Your Ref: OWPC22856
Our Ref: FG/42/19/HH 05-04-2019
Please ask for:
Zac Denton

Single storey front extension, side extension, conversion of garage to habitable use and conversion of roofspace to habitable use to include a rear dormer and 3 front rooflights.

22 Singleton Crescent Ferring

AR-138-05

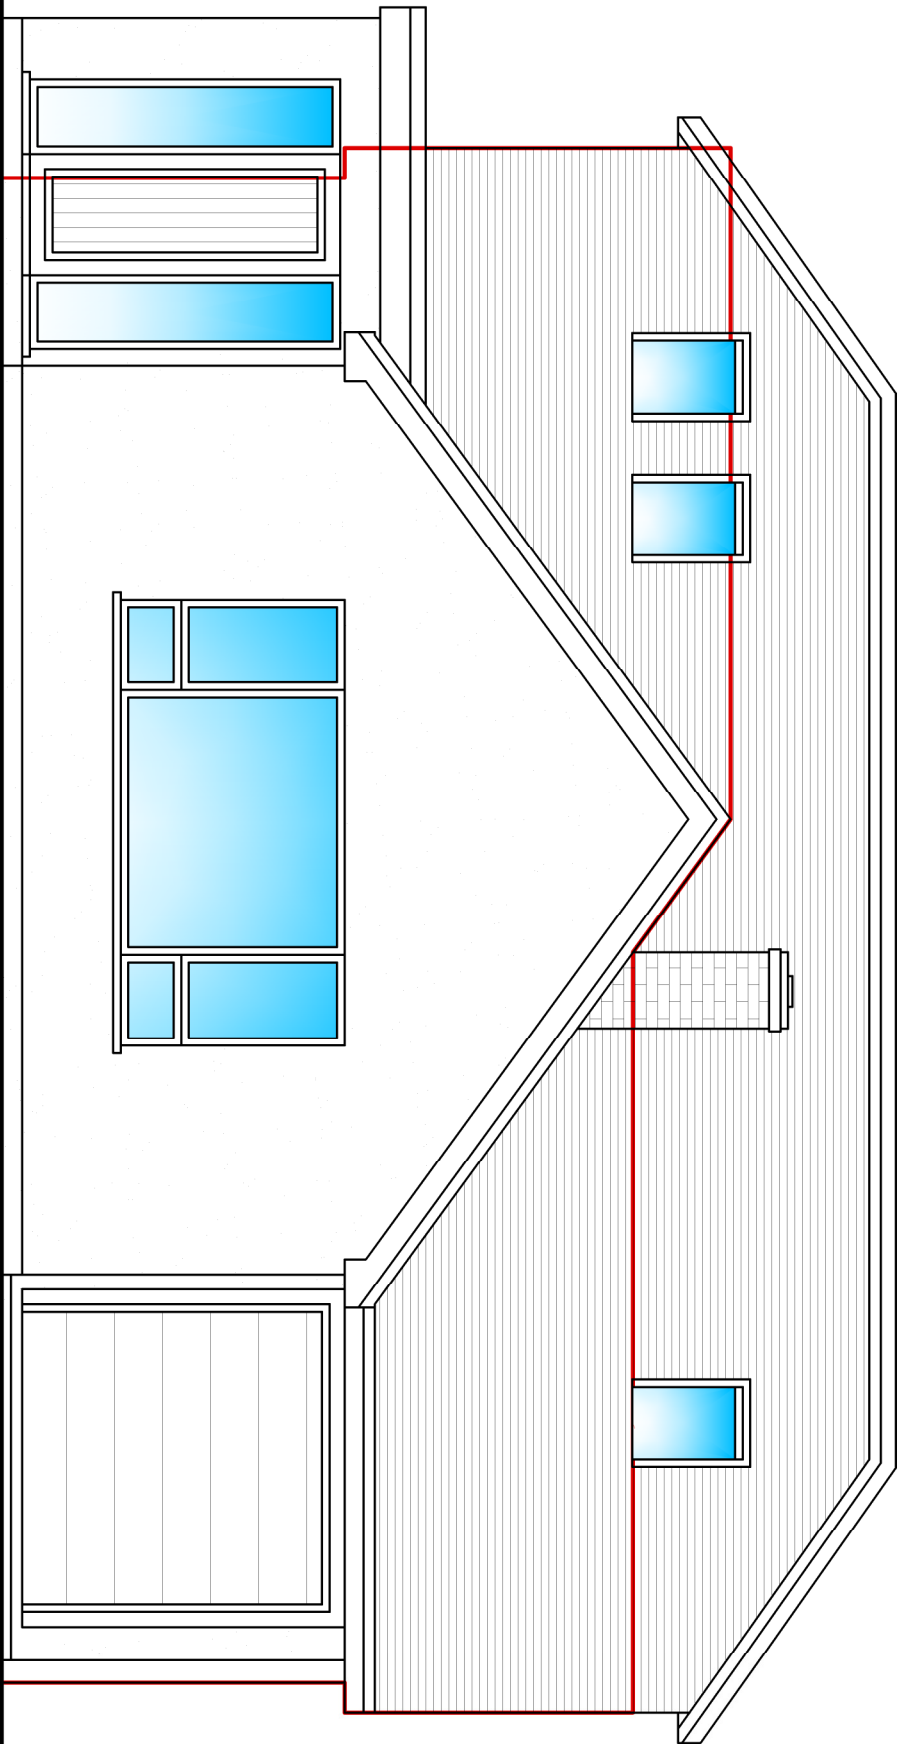
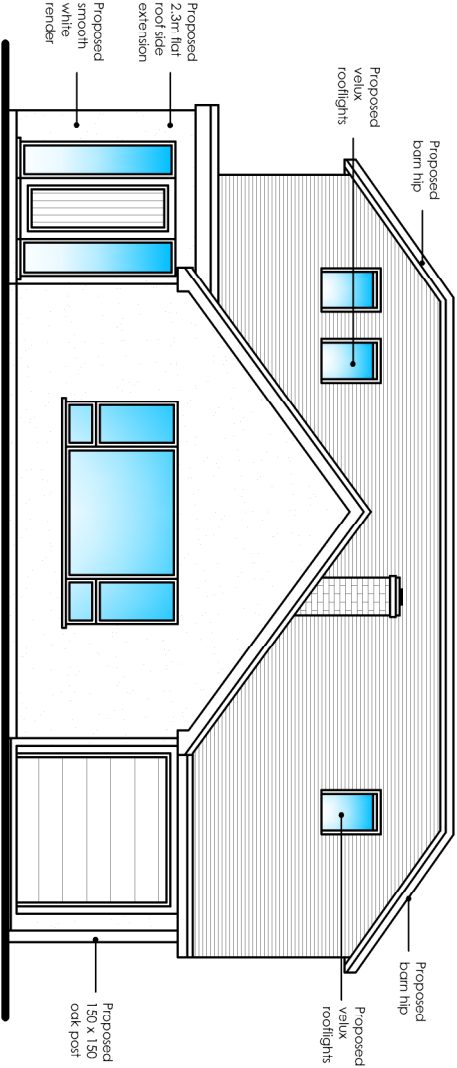
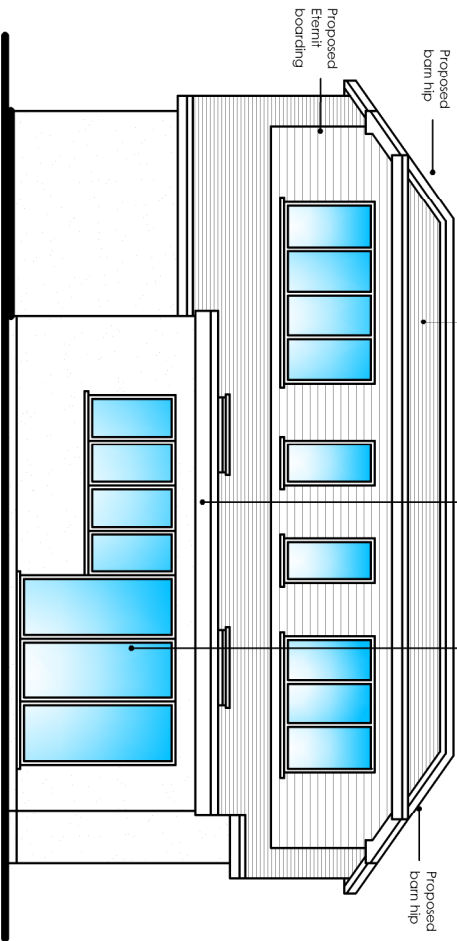
i am concerned with the potential impact on the street view and consequences for further development. With reference to AR-138-05 note 1 this shows no 43 and 45 singleton crescent neither have had their roofs raised and from the front view are exactly the same as when they were initially built so how does this proposed design replicate them note2 no 28 is 165 metres from no 22 in the far corner of the crescent set back from the road only partially visible behind 5x 12 metre high densely foliated trees so has no impact on the street scene.note3 no27 has also not had the roof raised and still retains the original street view .i am concerned that in effect this will be turning a view of bungalows of similar proportions into bigger and bigger houses and look out of character with the adjoining propertys.The footprint of these propertys so close to the road are bungalows not houses.
